Consultee response

FG/105/20/PL

The Tudor Close Public House, Ferringham Lane, Ferring, BN12 5NQ

Conversion of existing Public House (Use Class A4) to create 7 No residential units comprising 5 No 1-bedroom units & 2 No 2-bedroom units & the erection of 2 No 1-bedroom semi-detached bungalows, associated car parking & landscaping (resubmission following FG/46/20/PL).

# North Elevation

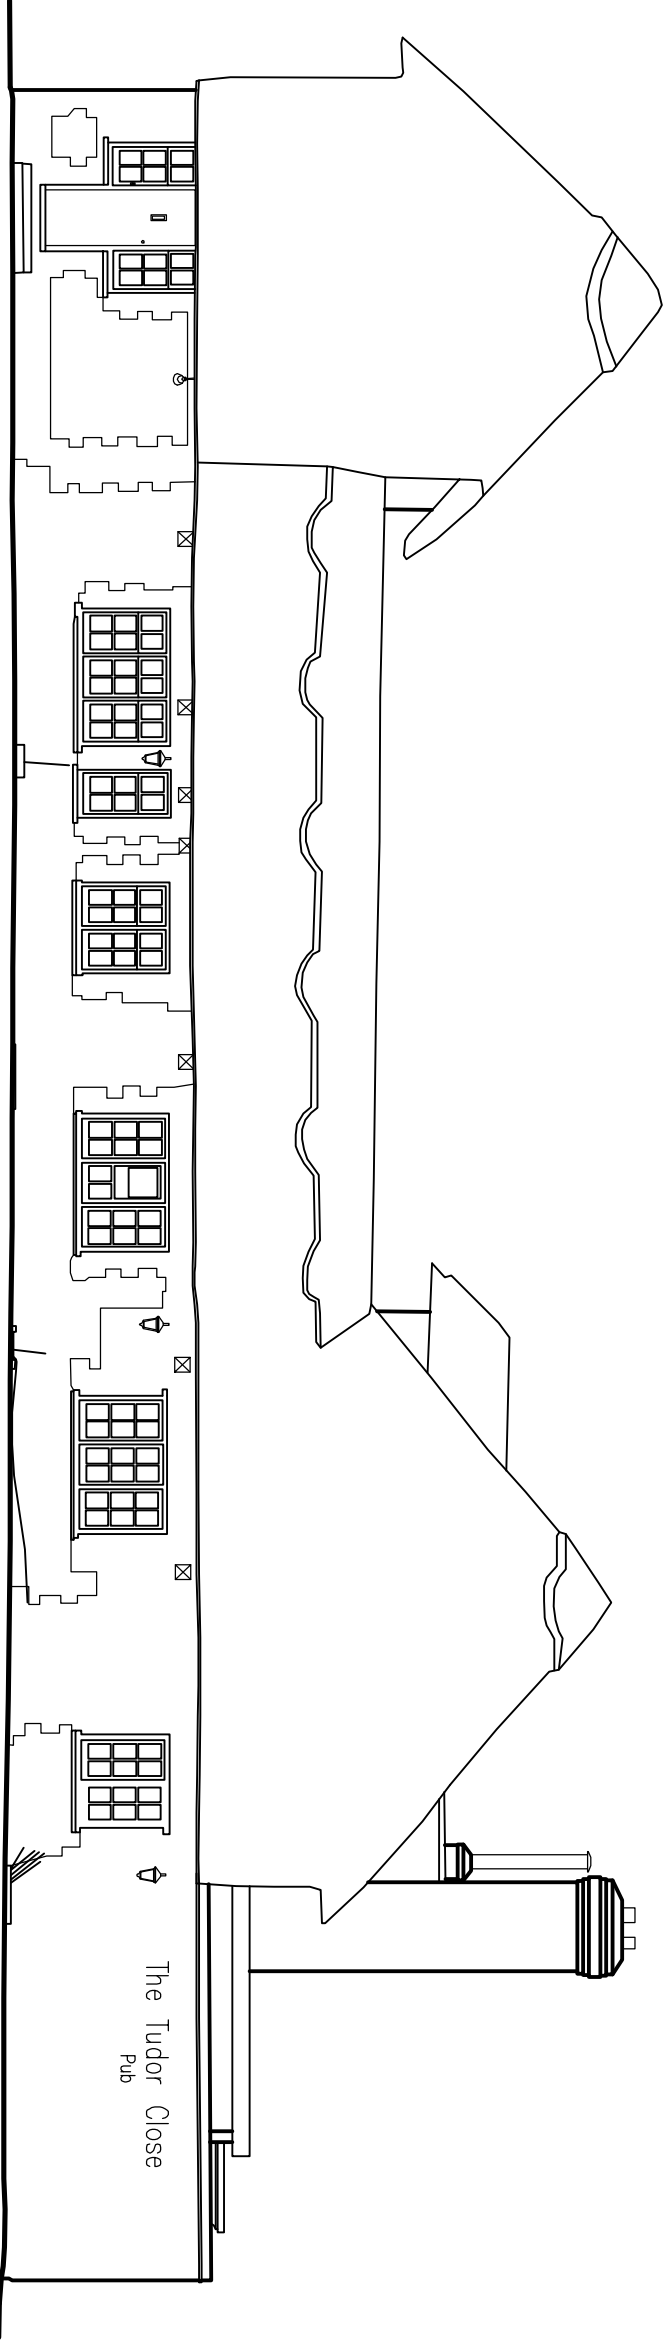
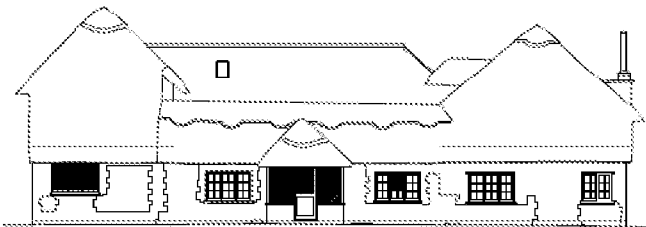
Alterations to the northern elevation of the building which include the removal of a door and windows and the installation of windows and a new porch will not harm the appearance of the building, subject to the design and materials of the joinery. Details of which should be provided for by way of condition, if you are minded to approve the application.
